Sunnica Ltd
2 Crossways Business Centre
Bicester Road
Aylesbury
HP18 0RA

21st January 2022

Application for a Development Consent Order for Sunnica Energy Farm

RE: Advice following issue of decision to accept the application for examination

**Drawing Title**  
 FIGURE 9-1  
 SURFACE WATER BODIES  
 AND THEIR ATTRIBUTES

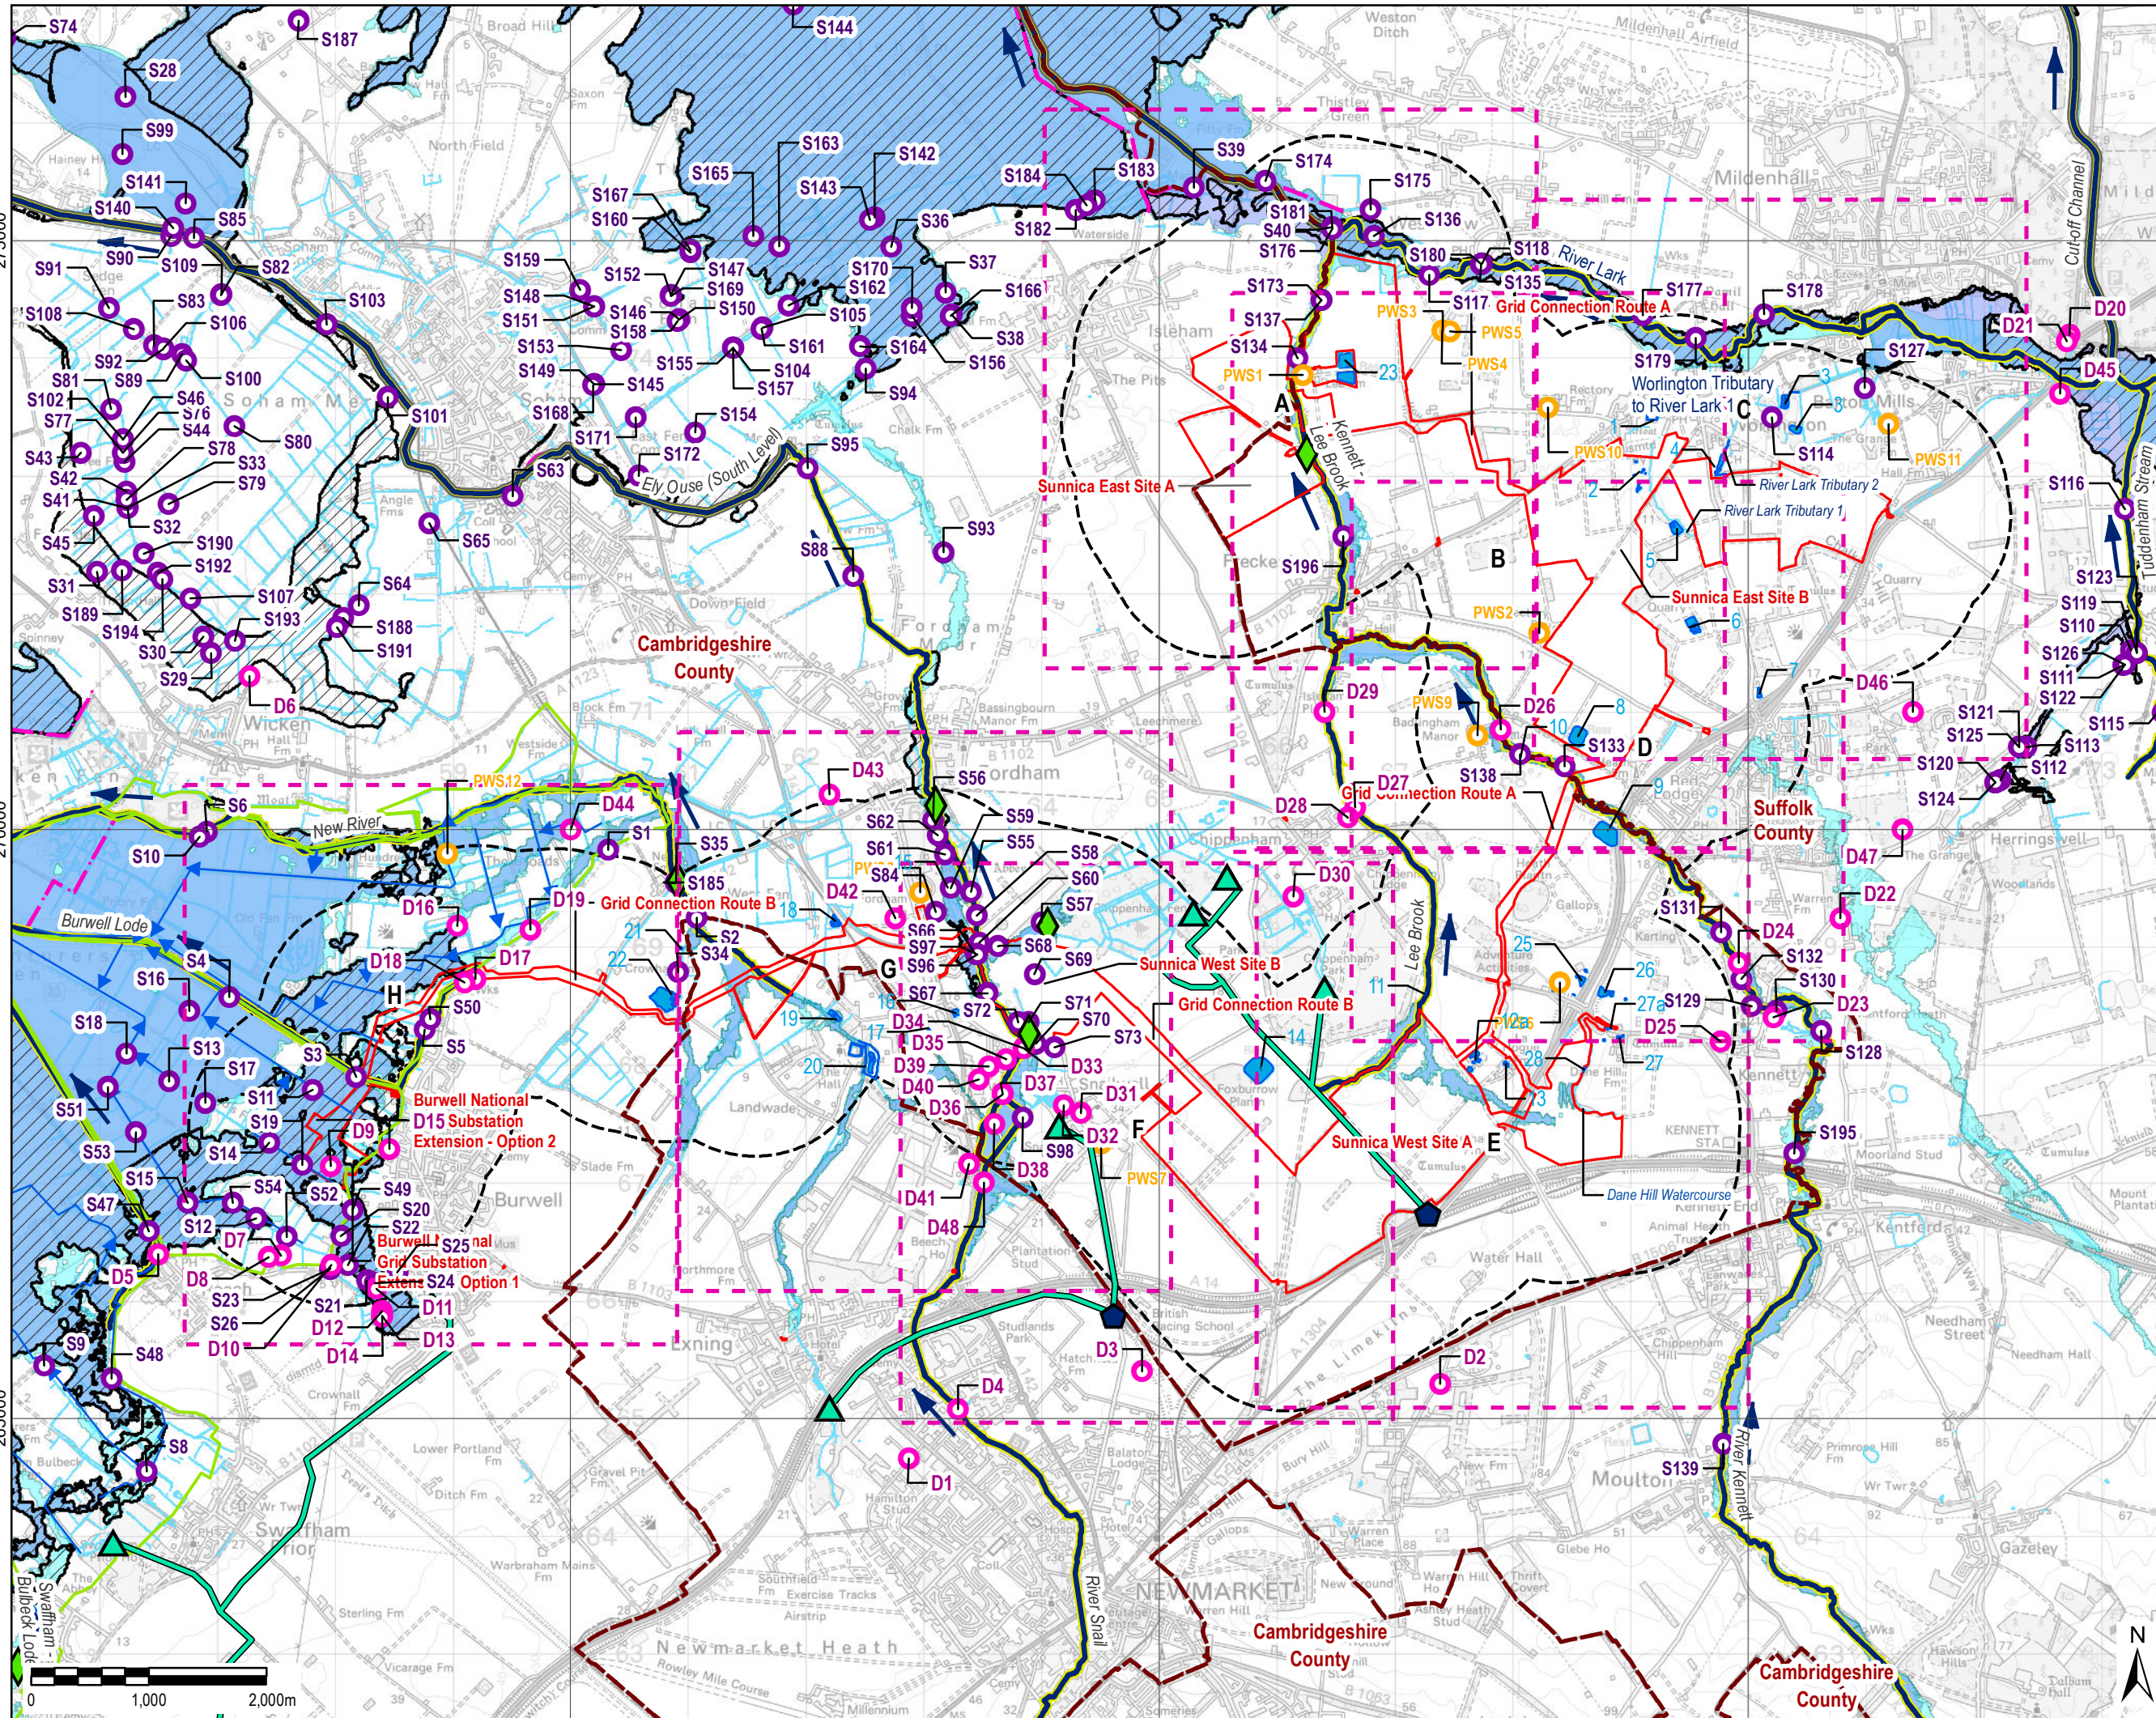
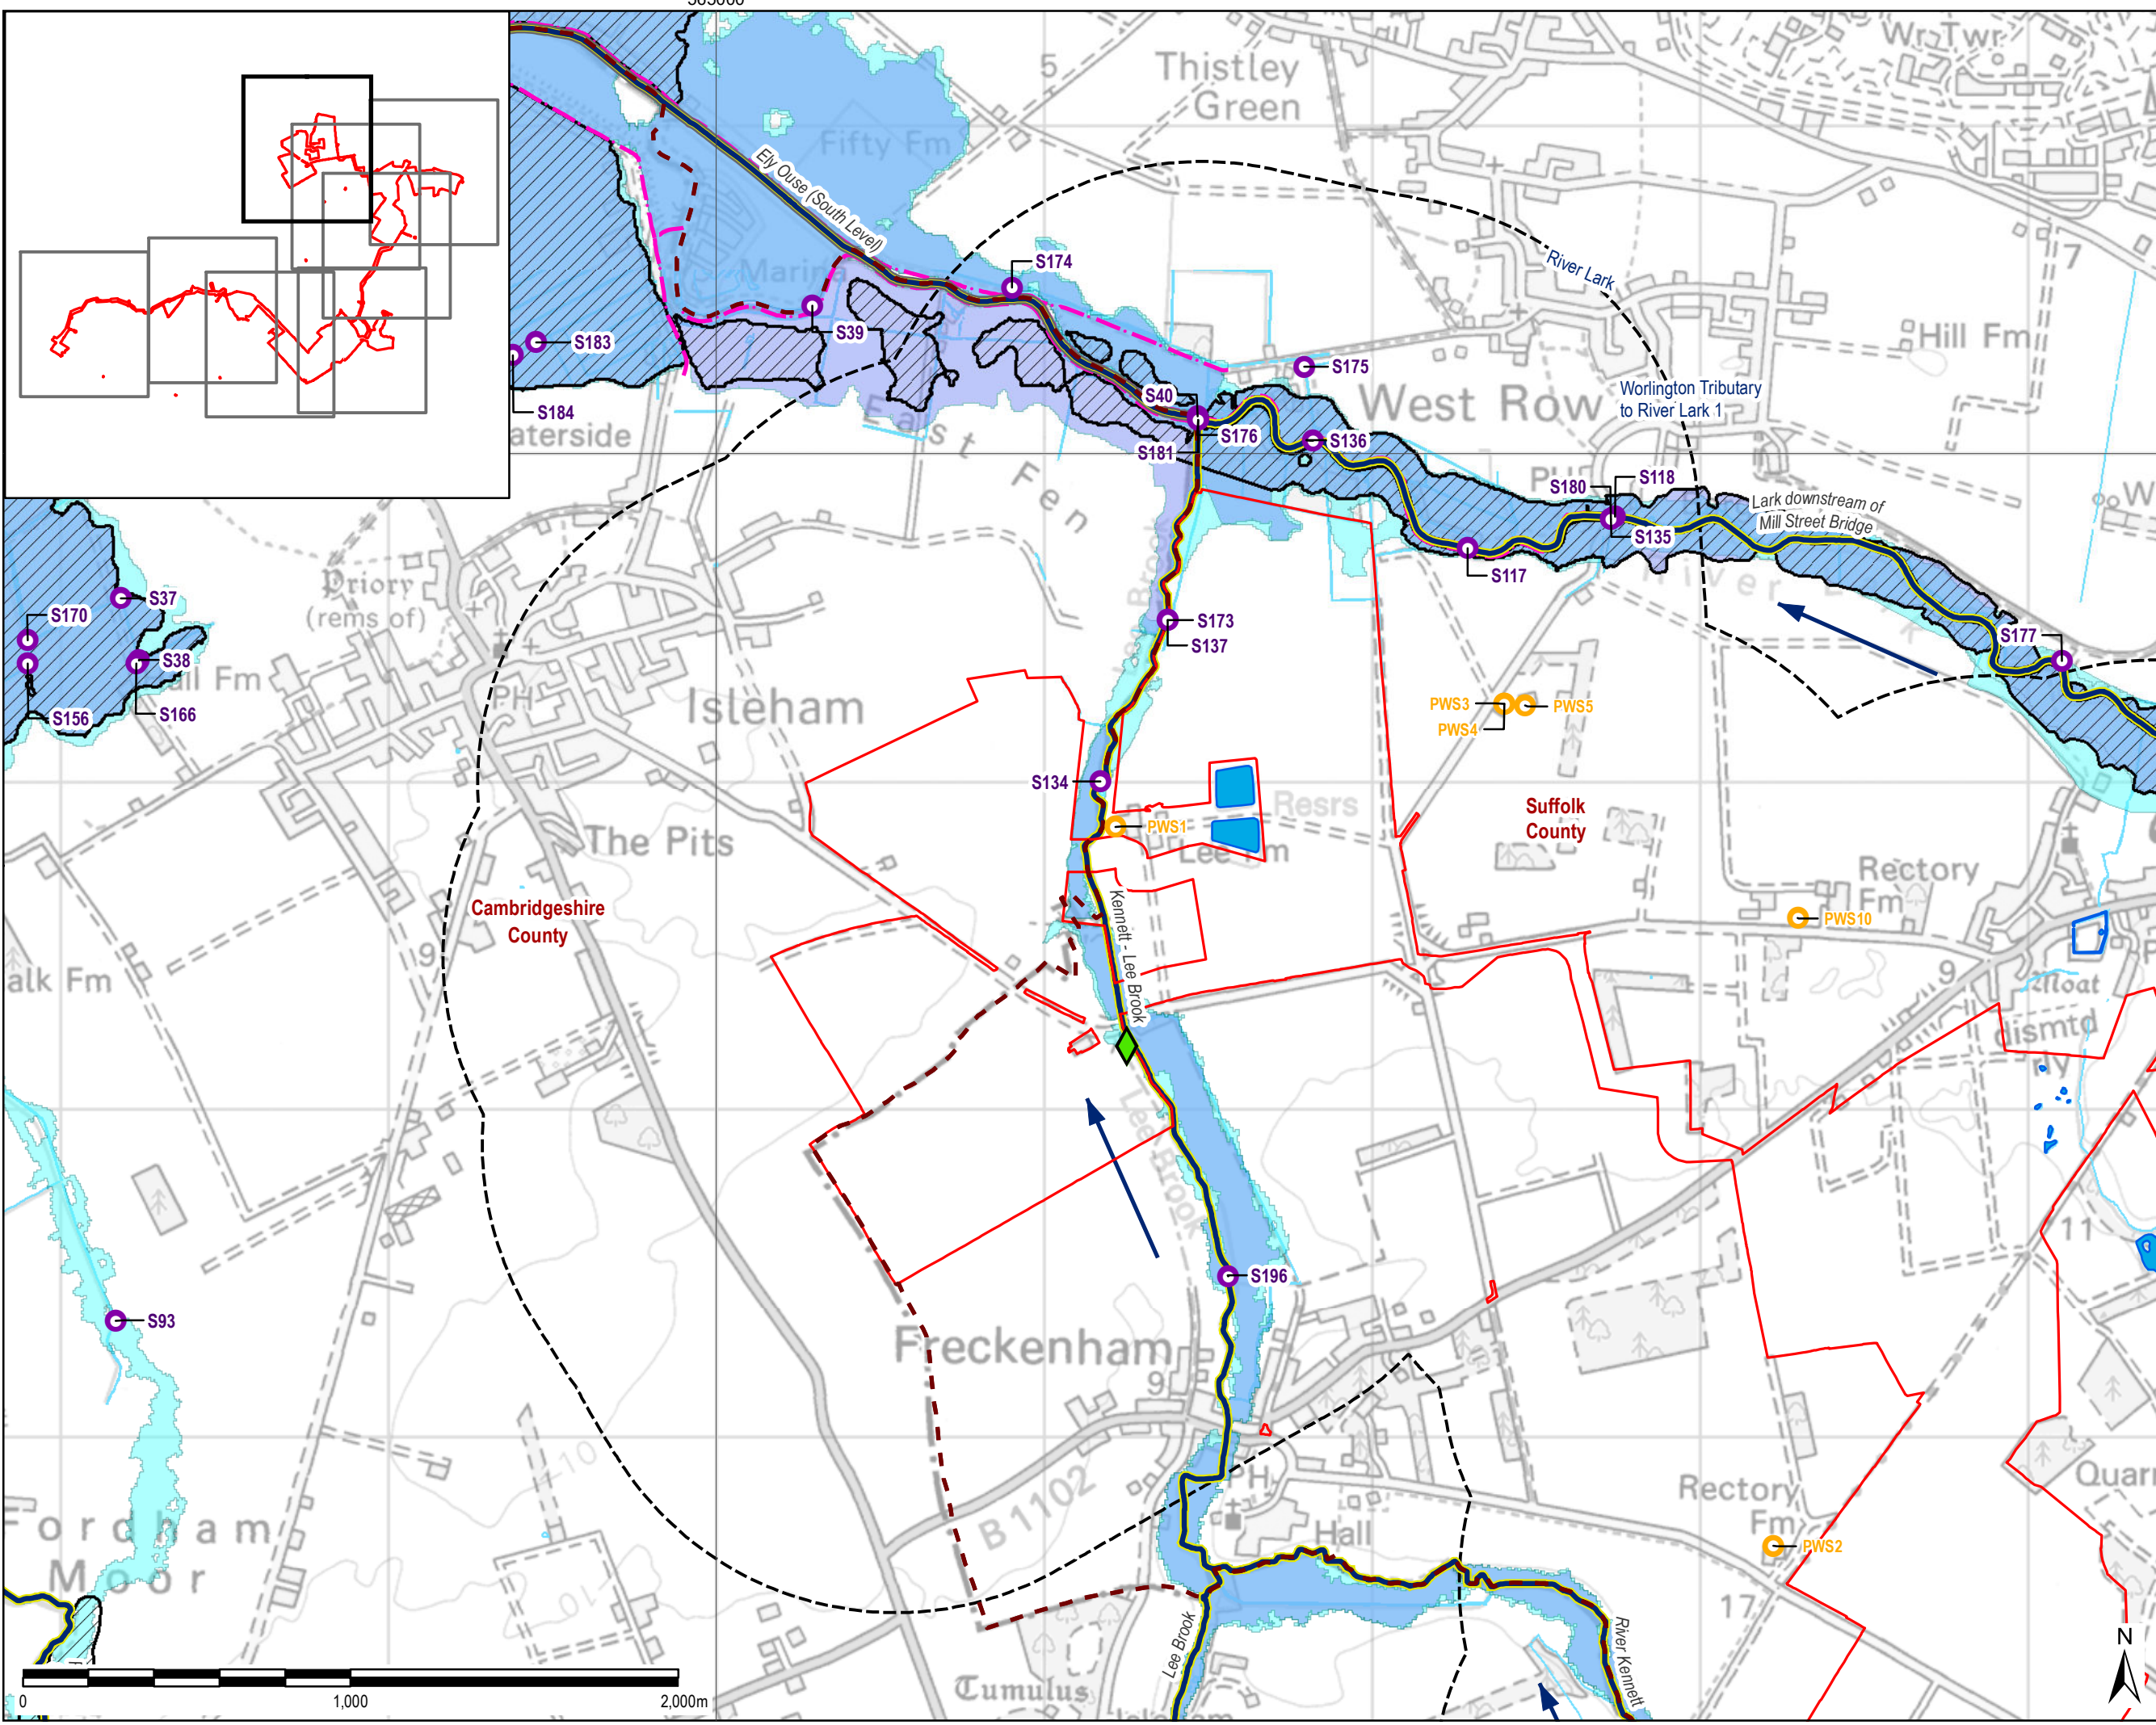
- 1.4.3 Revision 1 of Figure 9-1 of the Environmental Statement [APP-188] is provided to address the advice provided by the Planning Inspectorate.
